Planning Inspectorate

Case ref: EN0110013

Application by The Droles Solar Farm Limited for an order granting development consent for The Droles Solar Farm project.

Advice following issue of decision to accept the application for examination

## 2.7 Statutory Ecology and Nature Conservation Features Plan

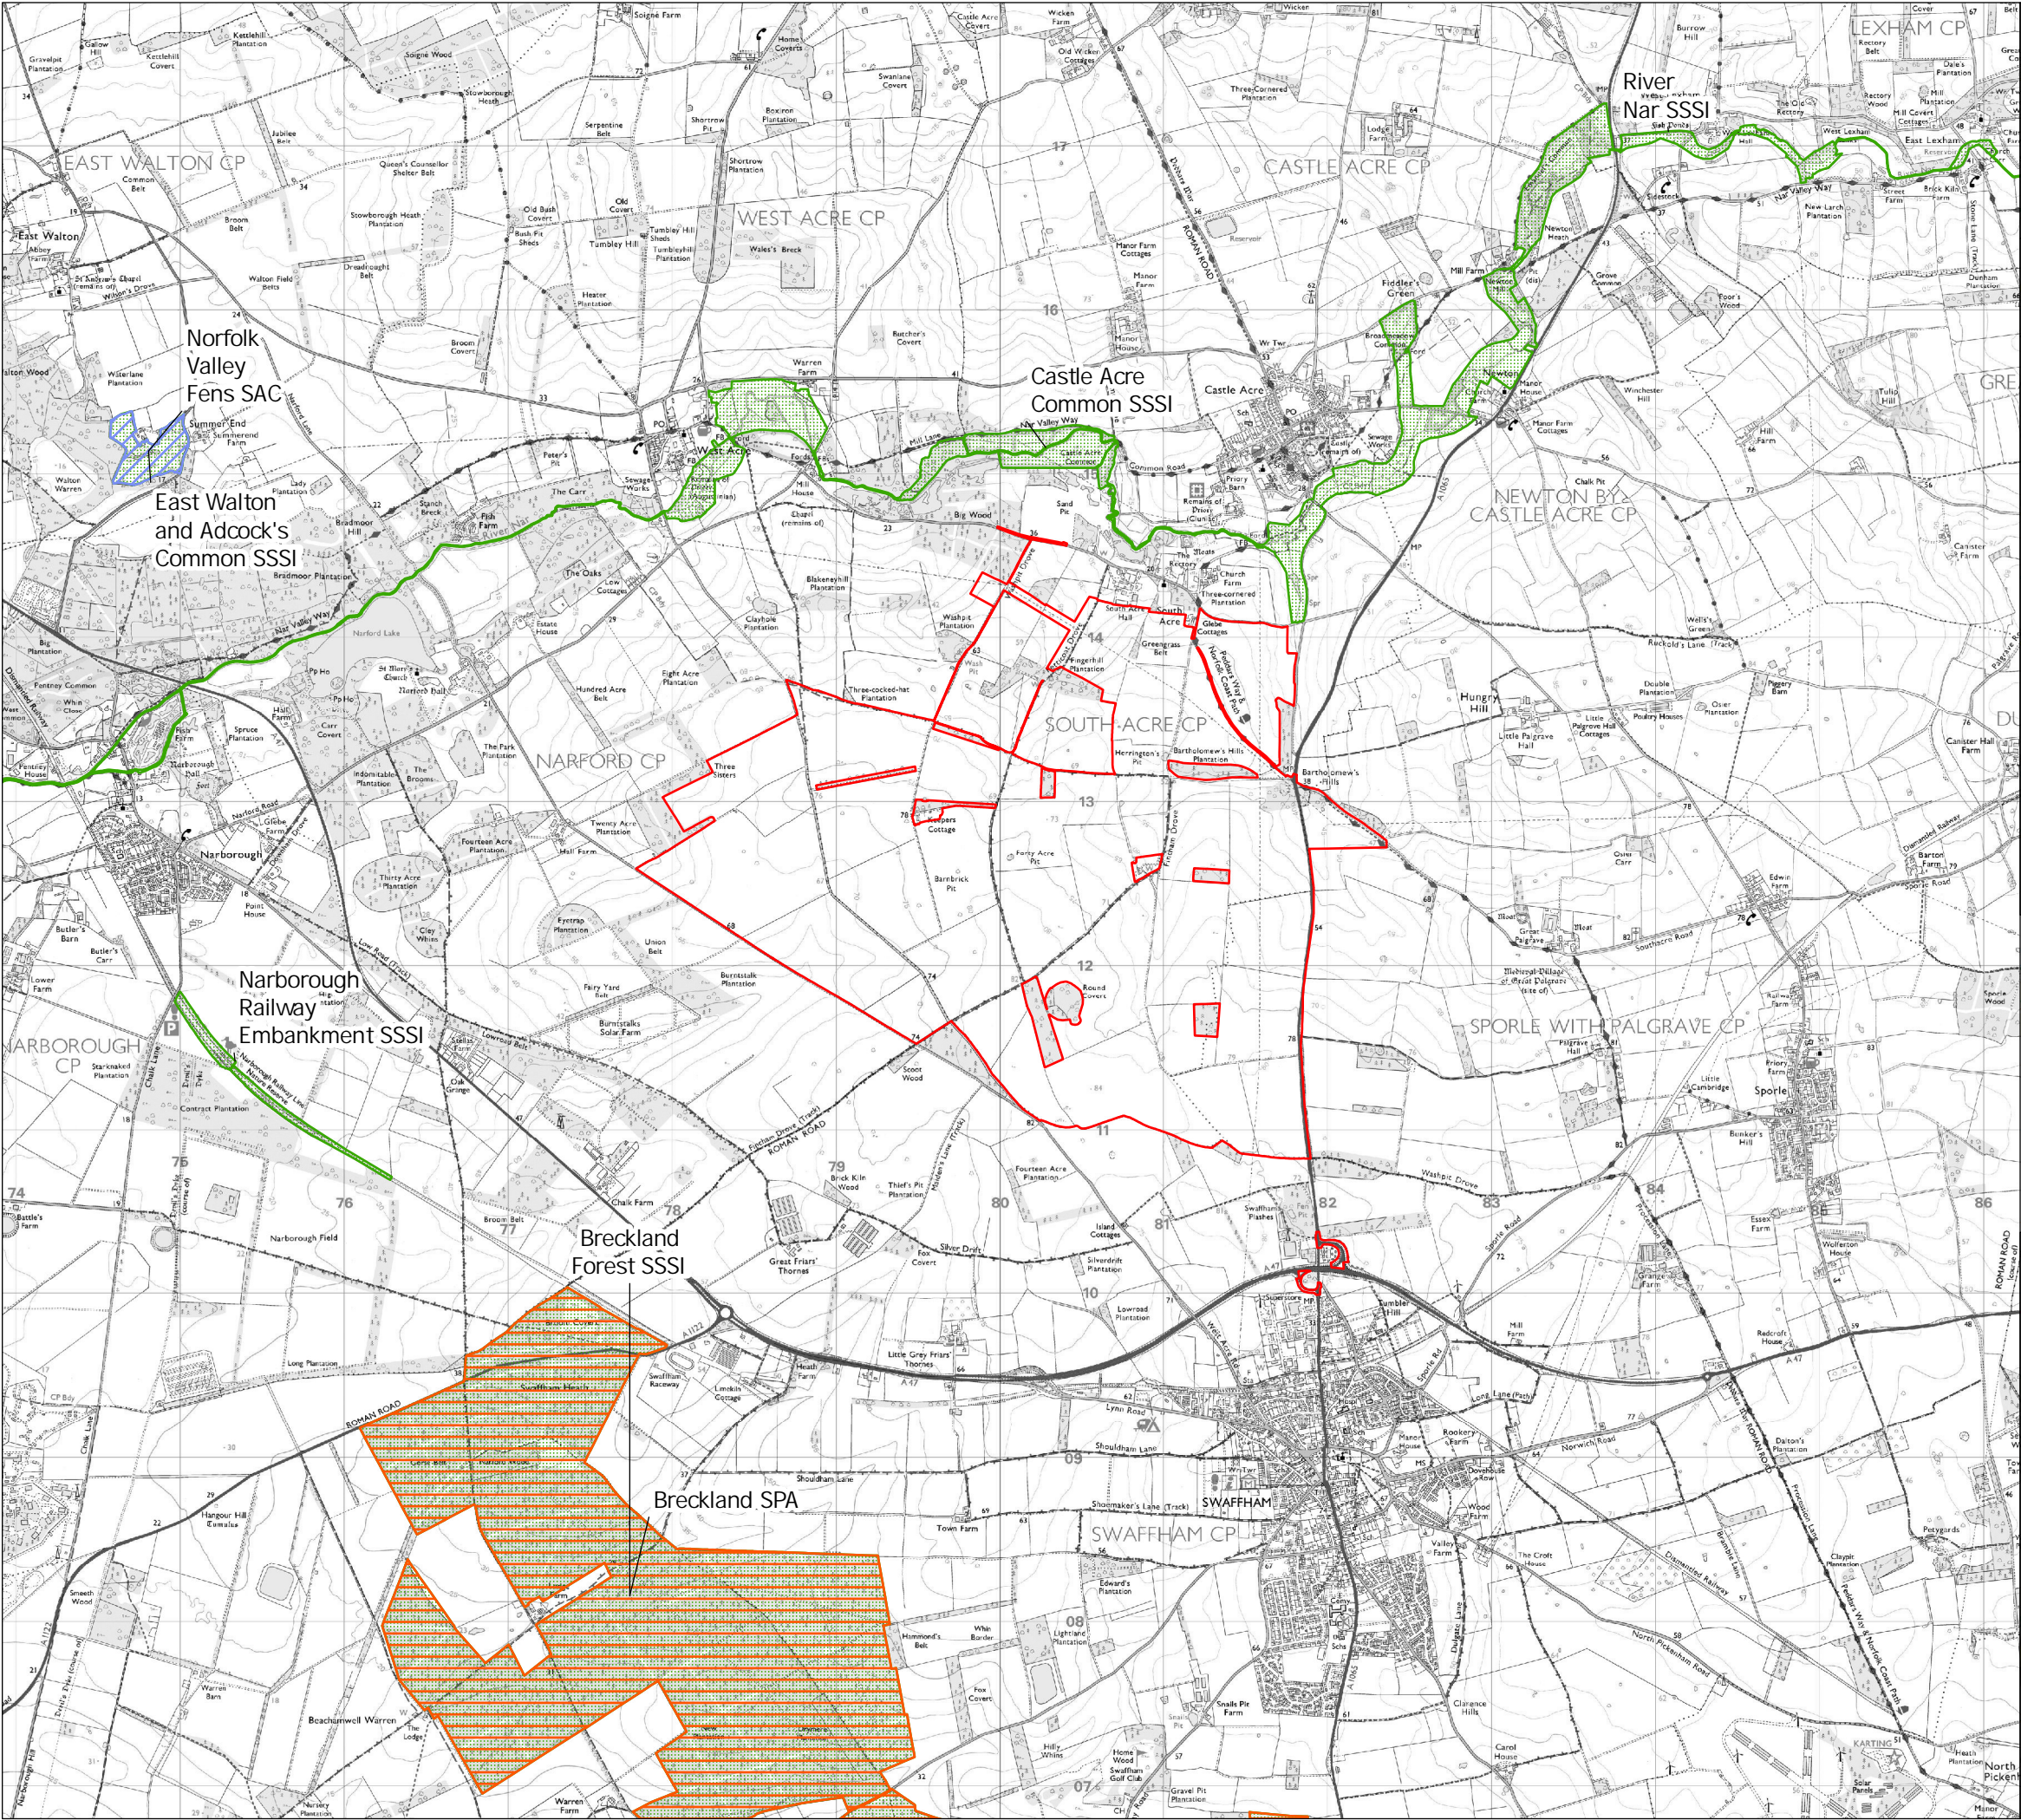
The Statutory Ecology and Nature Conservation Plan (Doc 2.7) appears to show an area which is less than the 25km distance used in the Environmental Statement's study area from the red line boundary of the order limits of the proposed development.

Could the applicant please provide a plan showing the full extent of the 25km study area.

Drawing file: published-documents / EN0110013-000624-6.3.1 ES Figure 6.5 Zone of Theoretical Visibility - DTM.pdf

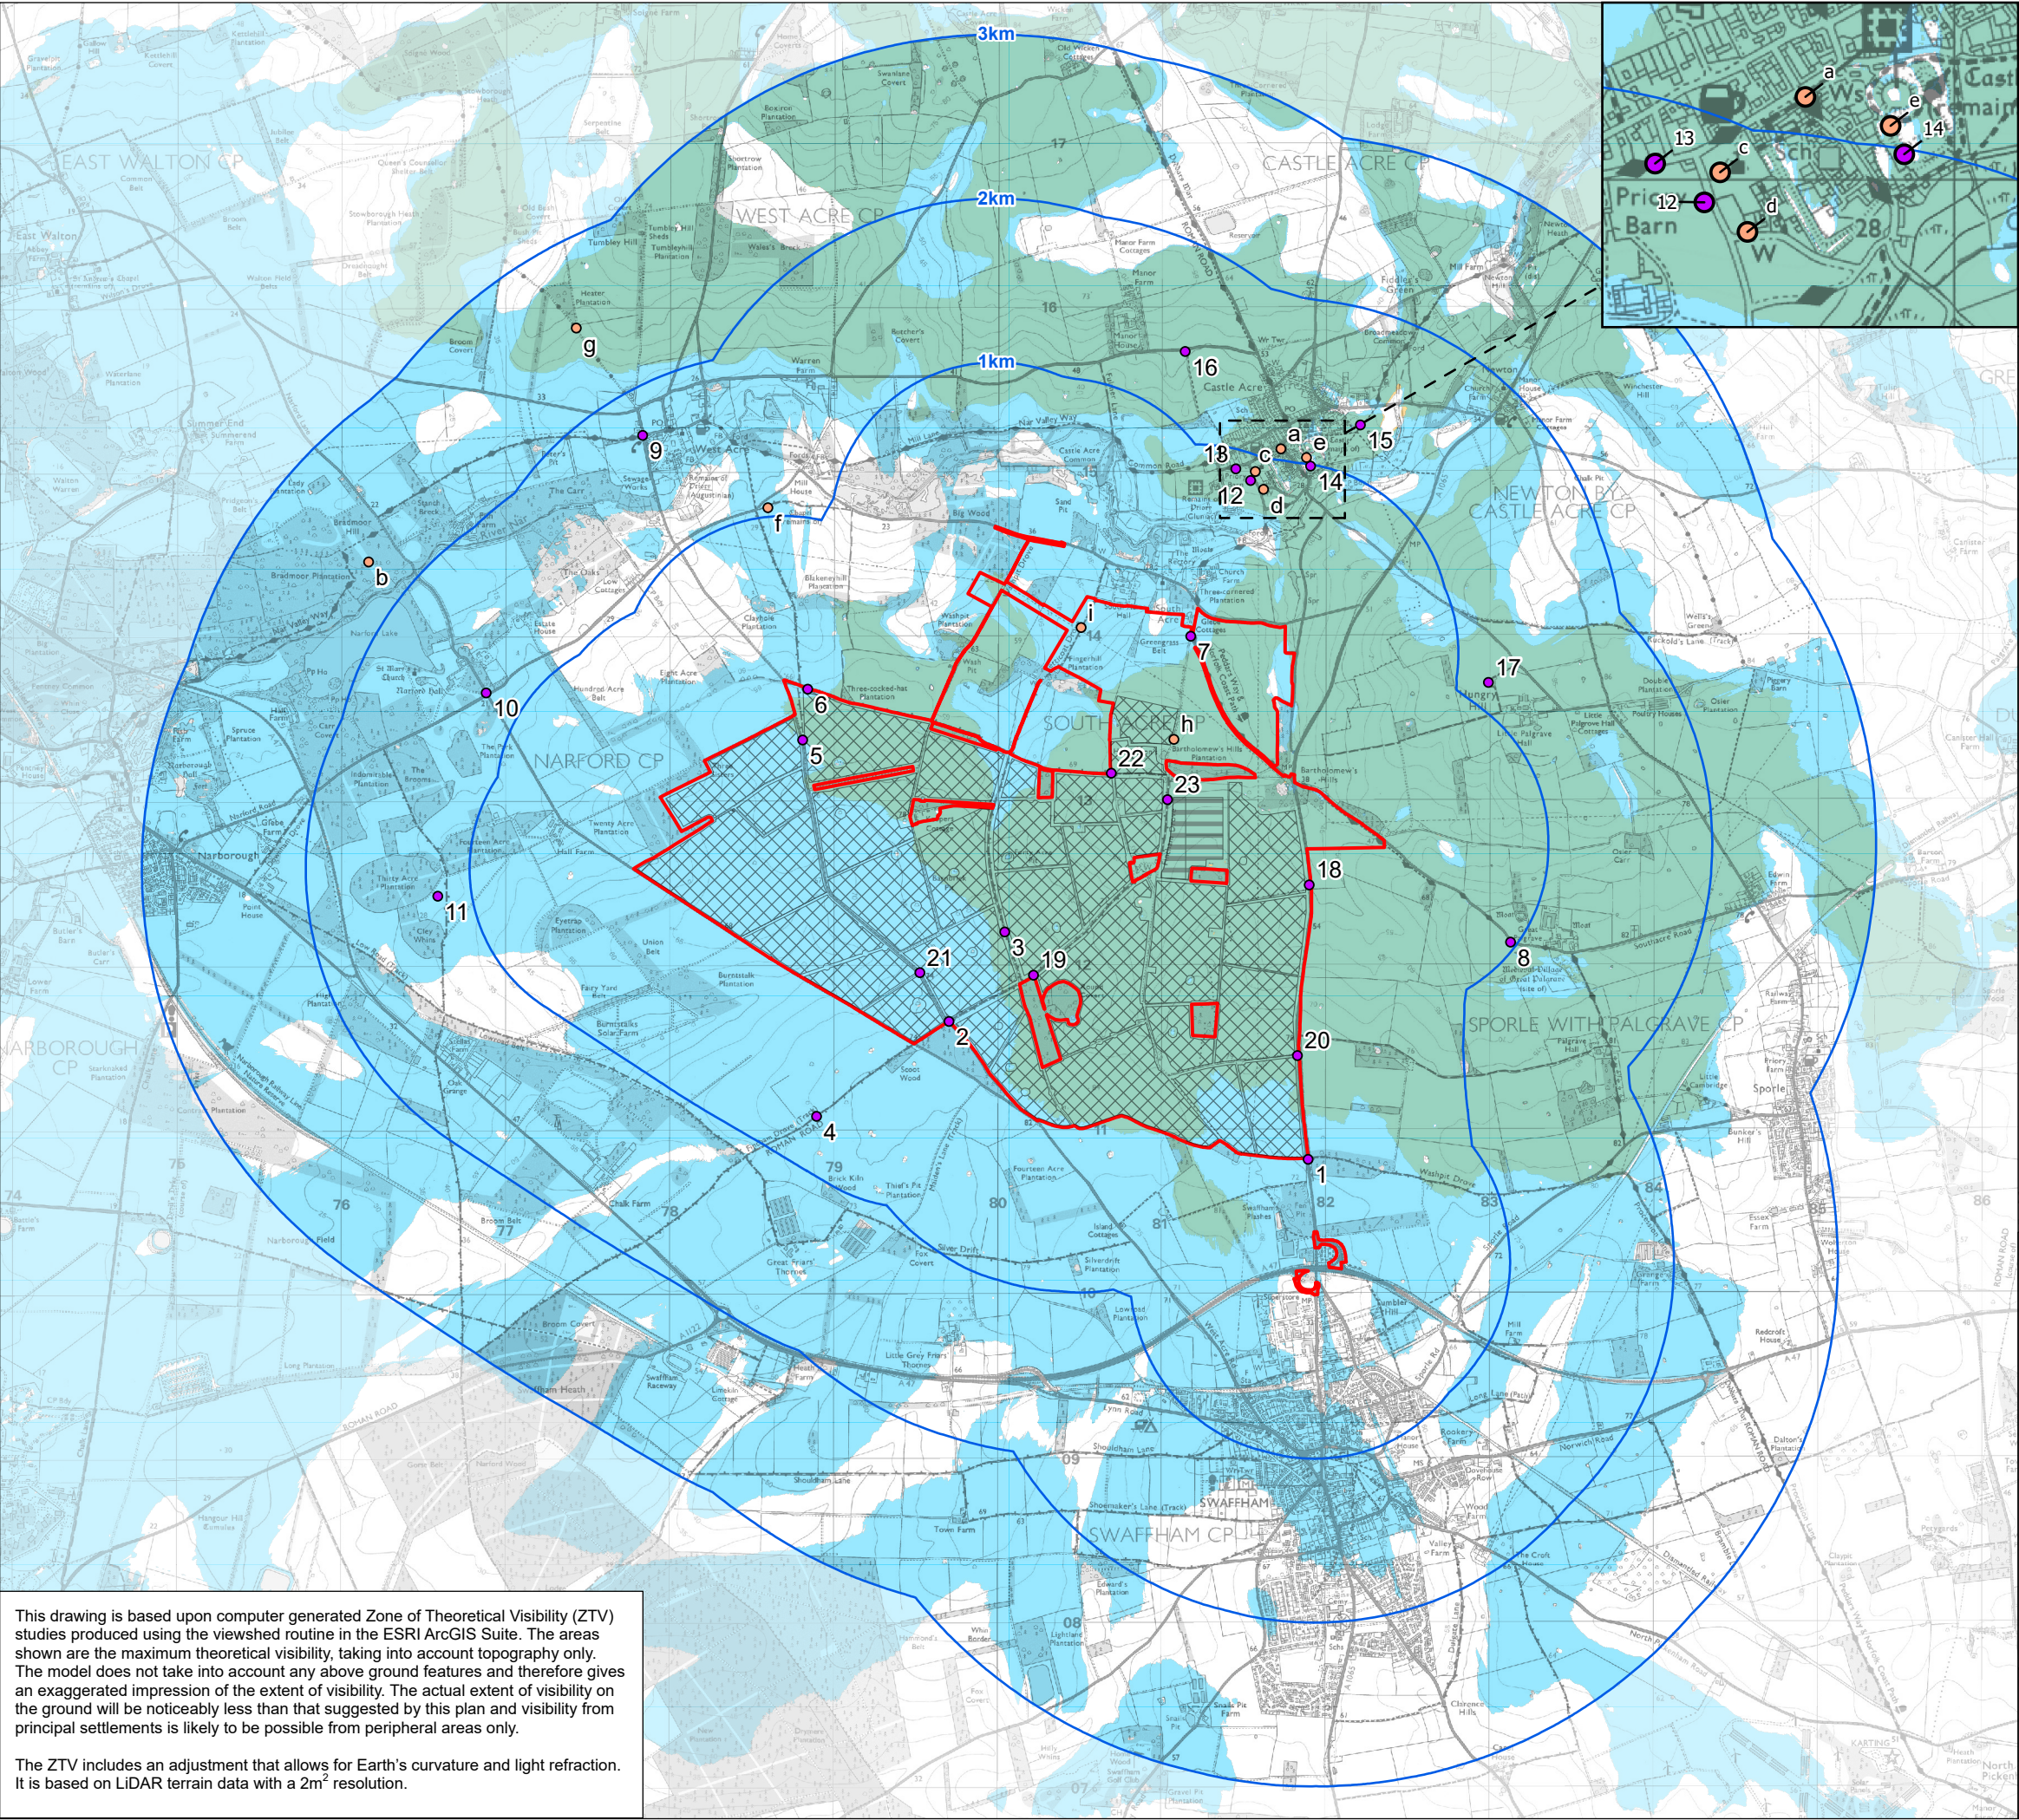
- Paragraph 6.2.4 in relation to ES Figure 6.6: Zone of Theoretical Visibility (DSM) refers to a digital terrain model, whereas paragraph 6.4.7 refers to DSM as Digital Surface Model.
- Paragraph 6.2.5 in relation to ES Figure 6.5: Zone of Theoretical Visibility (DTM) refers to digital surface datasets, whereas paragraph 6.4.8 refers to DTM as Digital Terrain Model

Please can the applicant provide clarification on the above points.
